ENG-SF21012-R2-TIS-redlines.pdf Markup Summary

Subject: EPC ENG Review
Page Index: 1
Date: 5/14/2021 5:07:27 PM
Author: dsdrice
Color: ■
Layer:
Space:
Page Label: 1

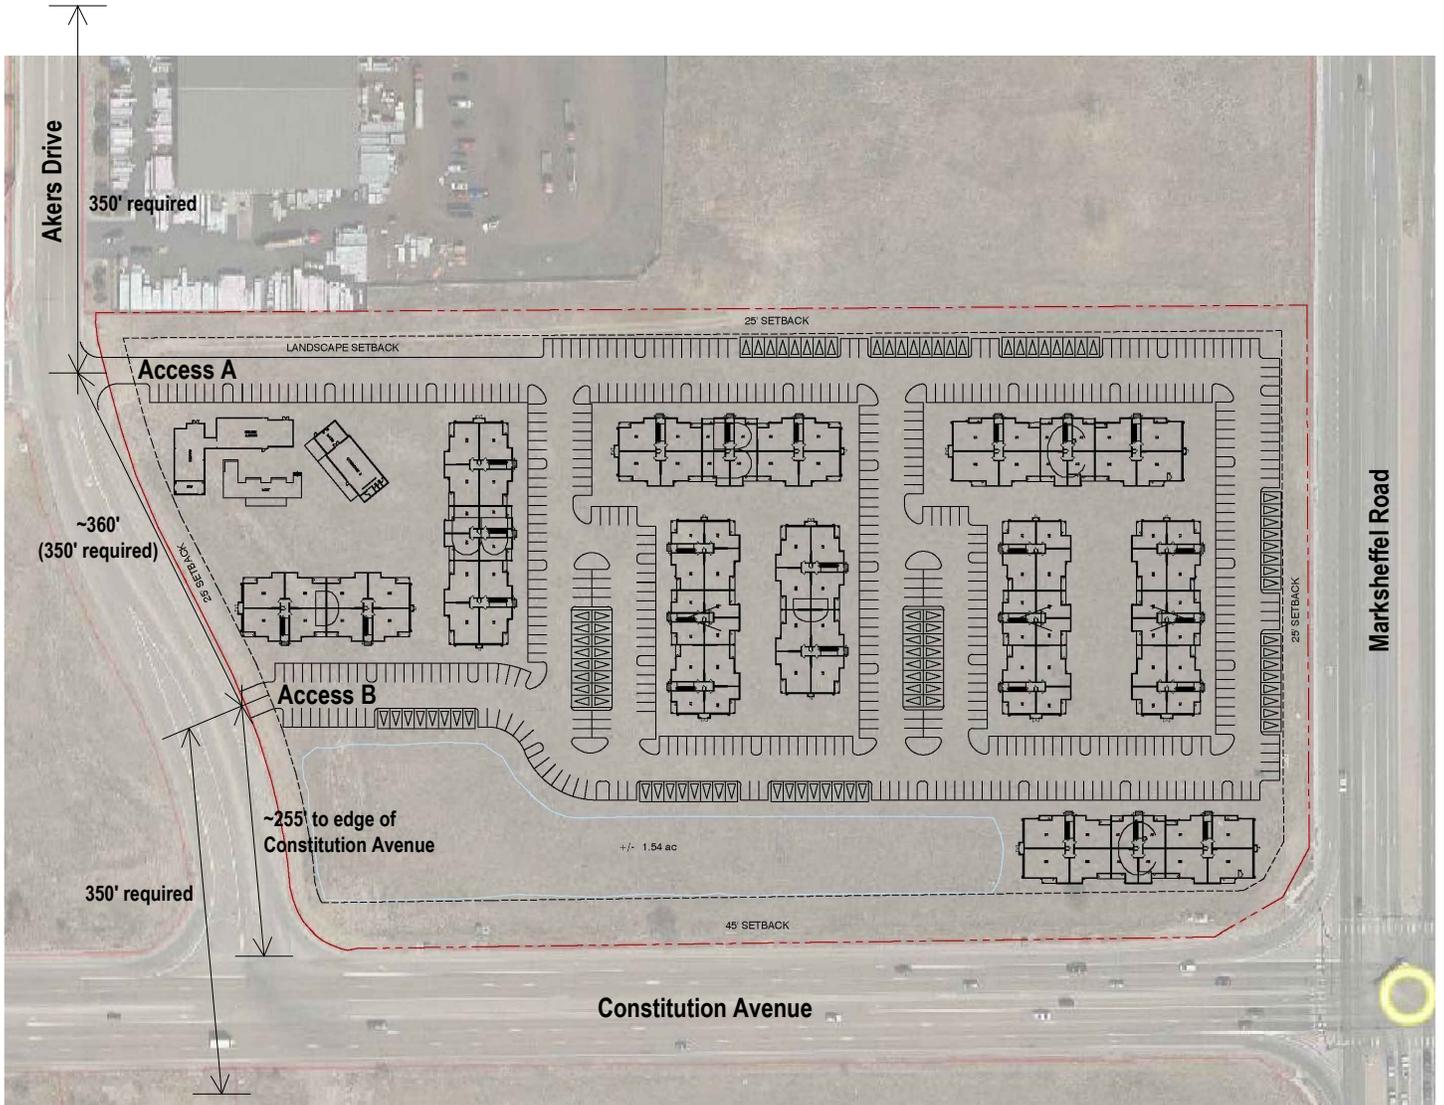
What about through-traffic when the intersection is completed?

Is there an adjustment for southbound traffic on Akers?

if adequate access spacing is provided

Show and label the required and available sight distances

315' required?
